Planning Application Ref: AW/281/19/T

Location: Strawberry Cottage, Cypress Way, Aldwick, PO21 4DF

Description of works: Reduce circumference by 3m and pollard by 3m 1no. Turkey oak tree. Reduce circumference by up to 3m away from property 2no. field maple trees

REF 1

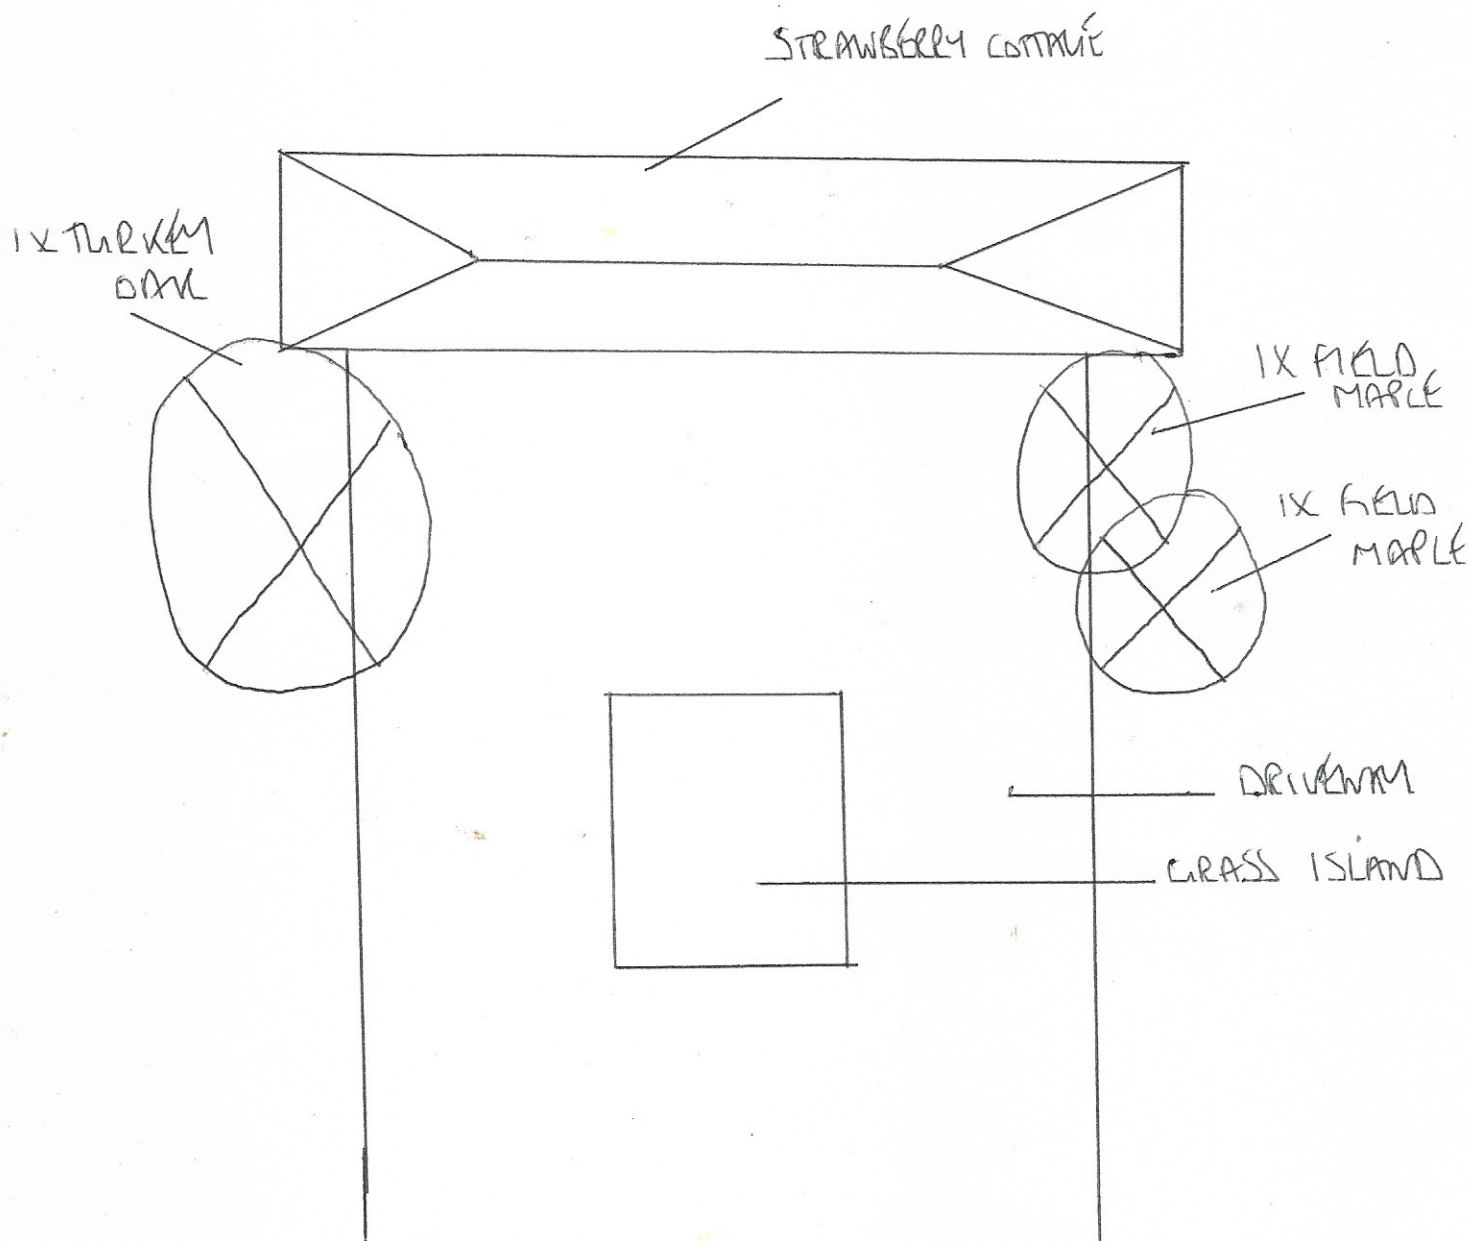
- **T1** – Outwardly and from a distance this tree appears to be in a fine physiological state but with a heavily modified crown. It has responded with vigour, typical for a healthy example of its type and in time could present an attractive crown profile when in leaf.

- **G276** – Both trees appear to be in fair physiological condition. The southernmost tree is multi-stemmed (possibly a cluster planting). Both have asymmetric form but are cohesive and together present an attractive crown profile despite an erratic pruning history. The applicant proposes a reduction in circumference. This is not a recognised tree work specification, so I have assumed it means lateral spread. Reduction in circumference alone, suggests an overall crown reduction (height and spread) is being sought. The proposal then further specifies ‘*Away from property*’ which suggests that future interference with built structures (existing dwelling and garden wall/arch brickwork) is the issue being addressed; that can only apply to the southernmost tree in the group.

- **T1** - This tree is not the subject of any Order nor worthy of such given it has been irrevocably spoilt by past pruning which has terminated the main stem at 6metres height and truncated the scaffold limb framework. Having been so compromised, at this location it will have to be managed long-term at similarly reduced dimensions to achieve an appropriate degree of structural integrity. Local planning authority consent for the work proposed is not required.

-
- **G276** - These trees require careful management that respect their age and vulnerability to environmental changes and disease progression.
 - The proposal to reduce both the height and lateral spread on all aspects (the correct interpretation of *crown reduction*) by 3m respectively would not comply with ‘British Standard (BS3998:2010) Tree work – Recommendations’ and be likely to result in harm to the health and vitality of the tree with large pruning wounds being formed as well as undermining their visual amenity value and impact in the landscape.

- As it stands, I recommend **REFUSAL** for this application.

- I would like to see the applicant submit a revised work specification such as detailed below, which would seem to address their concerns whilst preventing a diminution of the tree’s landscape and public amenity value:

G276 (southernmost tree) - Reduce/remove branches as necessary to achieve a maximum of 2metres clearance from built structures (main dwelling and garden wall/arch brickwork). Pruning wounds on completion of work must not exceed 100mm diameter.
